From: [Dusty Pilkington](#)
To: ["Cruse & Associates"](#)
Subject: RE: BL-18-00011 Fyall
Date: Tuesday, October 02, 2018 8:06:25 AM

From: [Dusty Pilkington](#)
Sent: Monday, October 01, 2018 3:07 PM
To: ["Cruse & Associates"](#)
Subject: BL-18-00011 Fyall

In the process of reviewing the Fyall BLA, I have some questions.

CRUSE & ASSOCIATES
PROFESSIONAL LAND SURVEYORS
217 East Fourth Street P.O. Box 959
Ellensburg, WA 98926 (509) 962-8242
FYALL/BULL PROPERTY

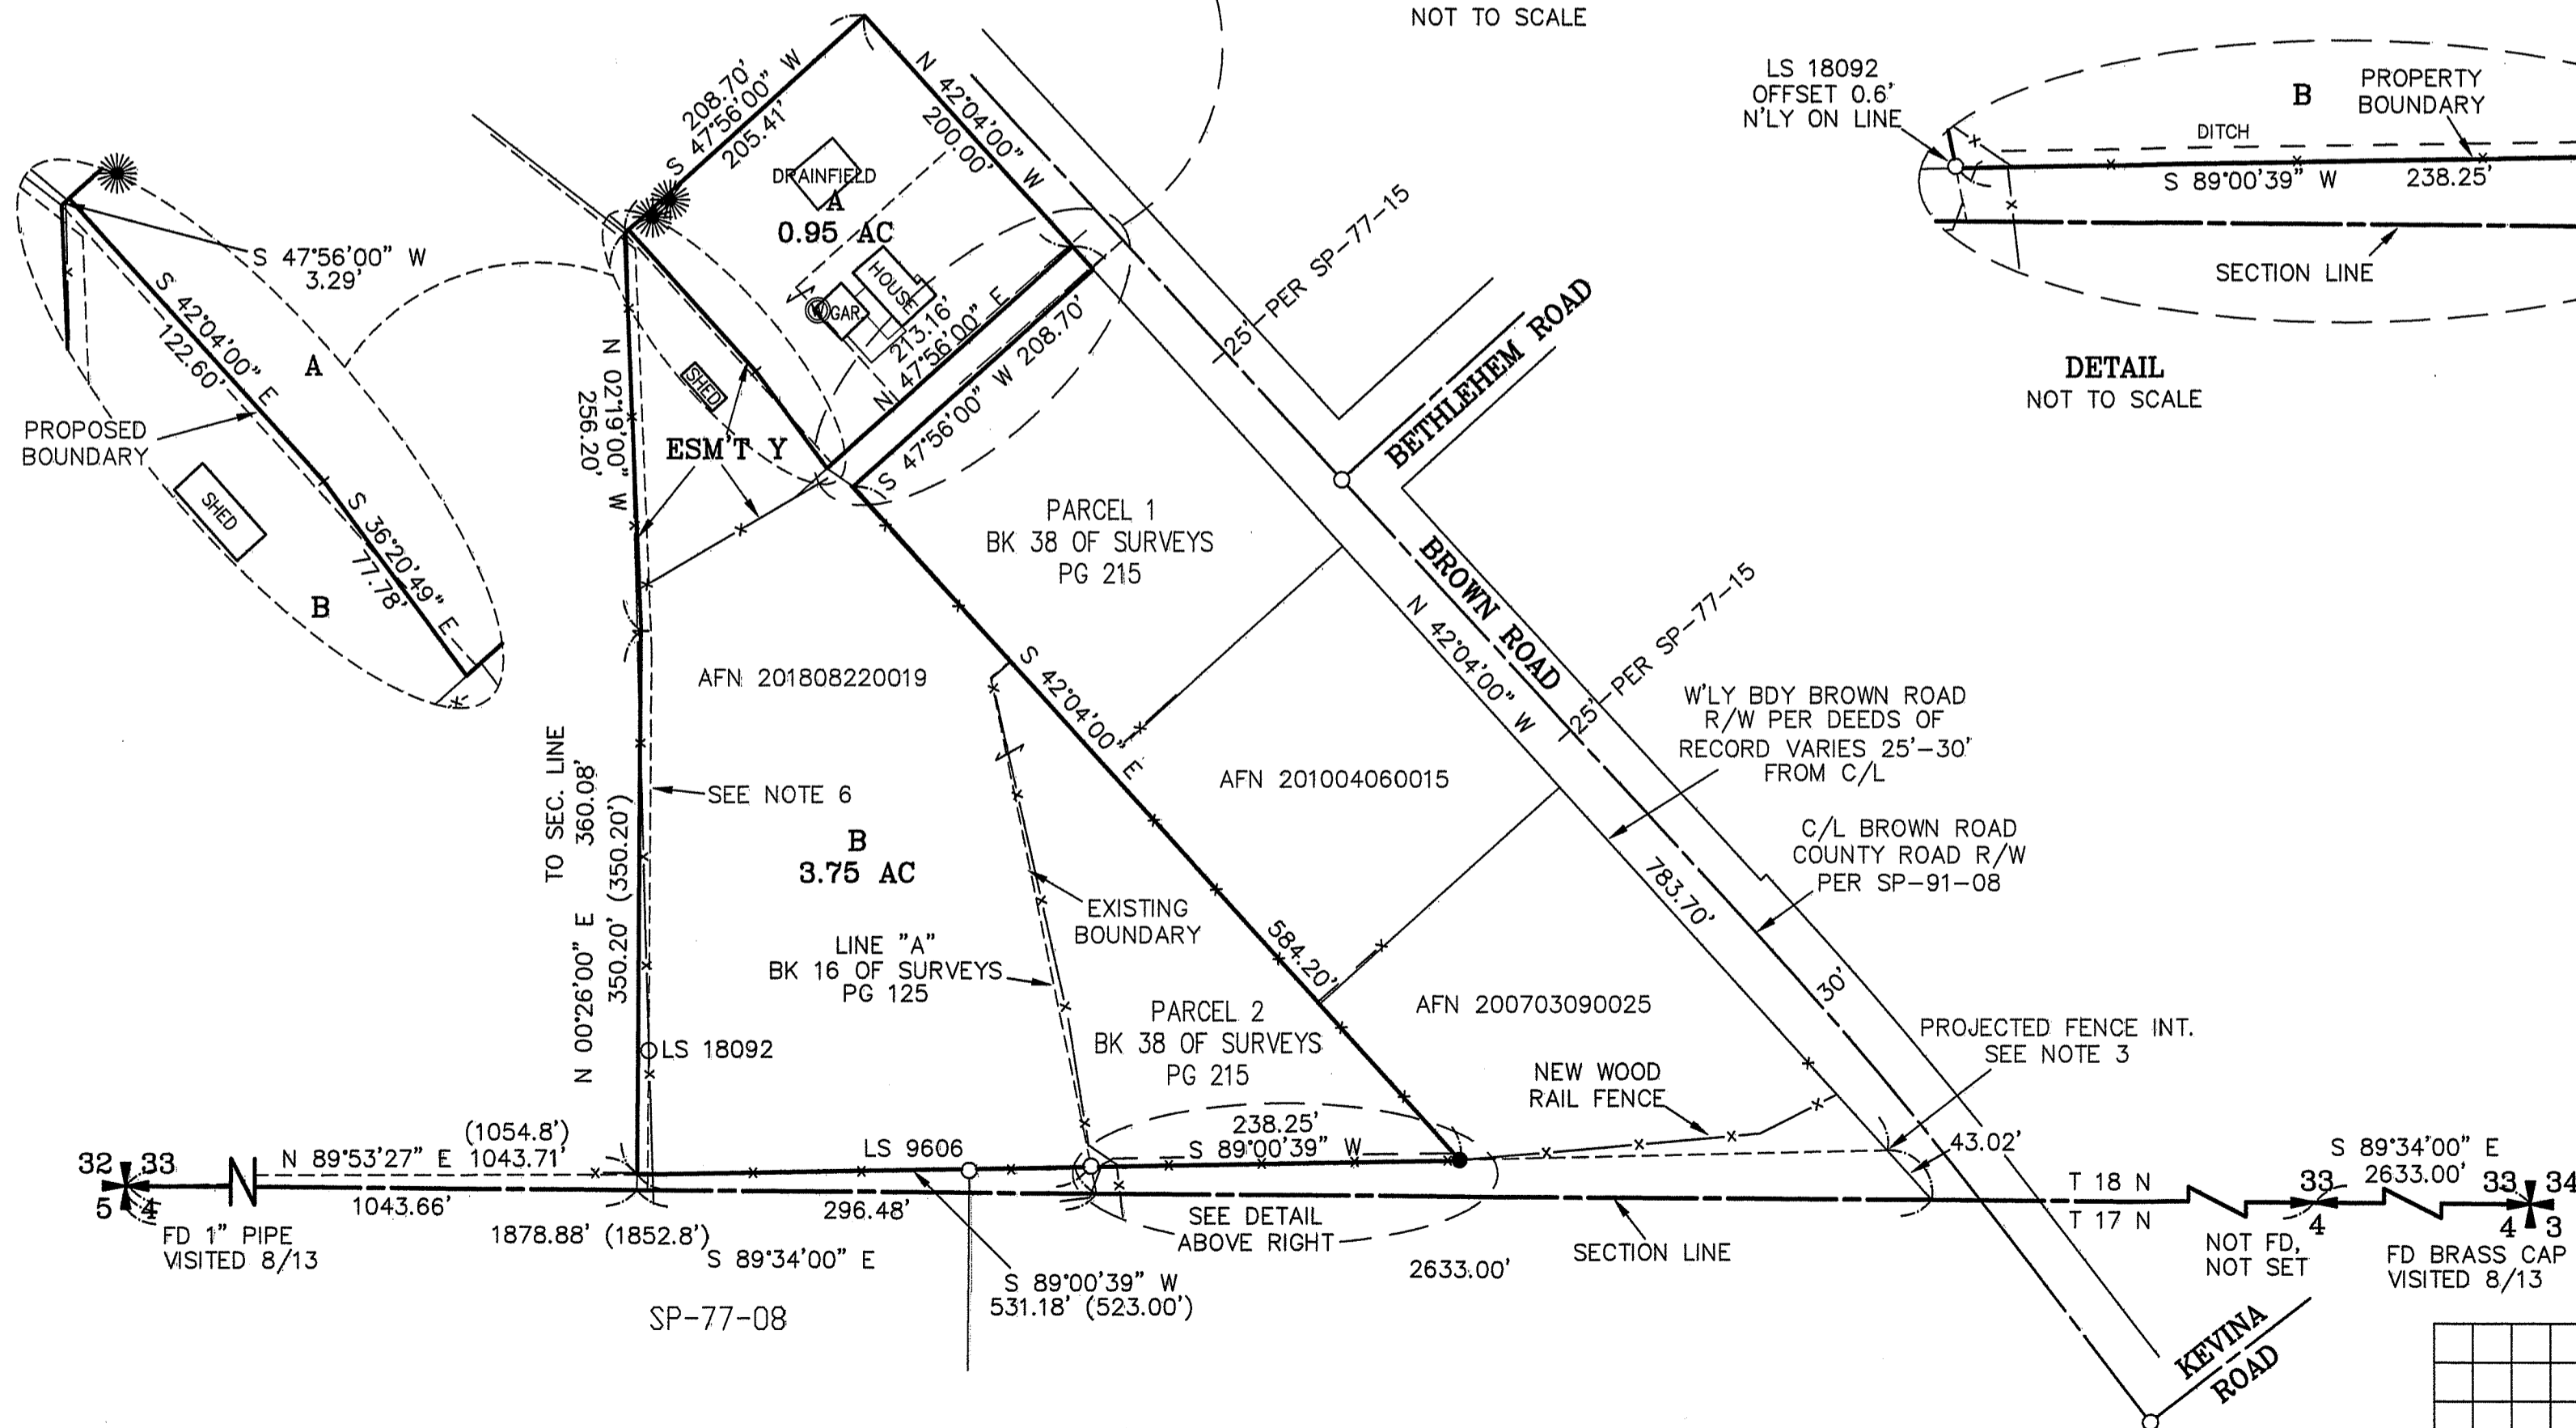
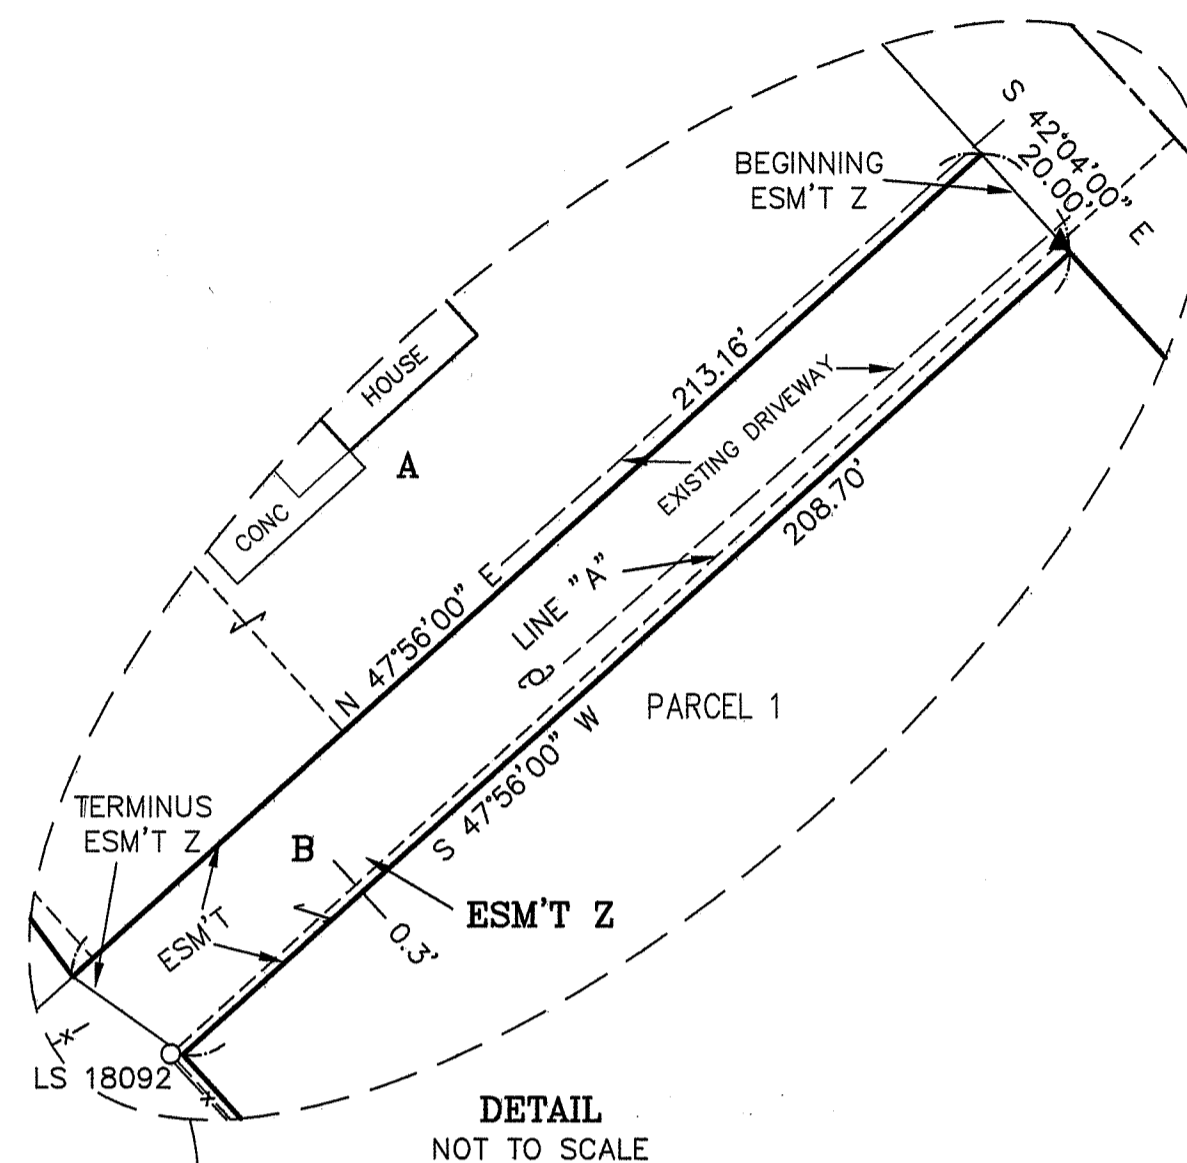
- 1) There is an apparent discrepancy in the acreages shown on the BLA. In the Assessor's records, parcel 879333 has an area of 3.64 acres, and parcel 160136 has an area of 0.95 acres, for a total of 4.59 acres. On your "preferred" site plan the acreages are 1.30 and 3.4 acres, for a total of 4.7 acres. On the "alternate", the acreages are 0.95 and 3.64, for a total of 4.59 acres. Could you explain the discrepancy, and where the extra .11 acres comes from on the "preferred" version?
- 2) A drainfield is shown, but the location of the septic is not. There are no wells drawn, and the narrative makes no mention of whether the or not the parcels are served by a water source other than a well. The site plan or the narrative may require a revision,

either to depict water source well on the drawing, or to update the narrative to reflect the water source.

The well is inside the garage. I see we listed the well as a symbol in the legend on the survey but is hard to distinguish with the garage walls running through it. Attached is a quick redline of the well location. The septic tank is next to the house and can add it to the site plan while we update. Sorry for the confusion.
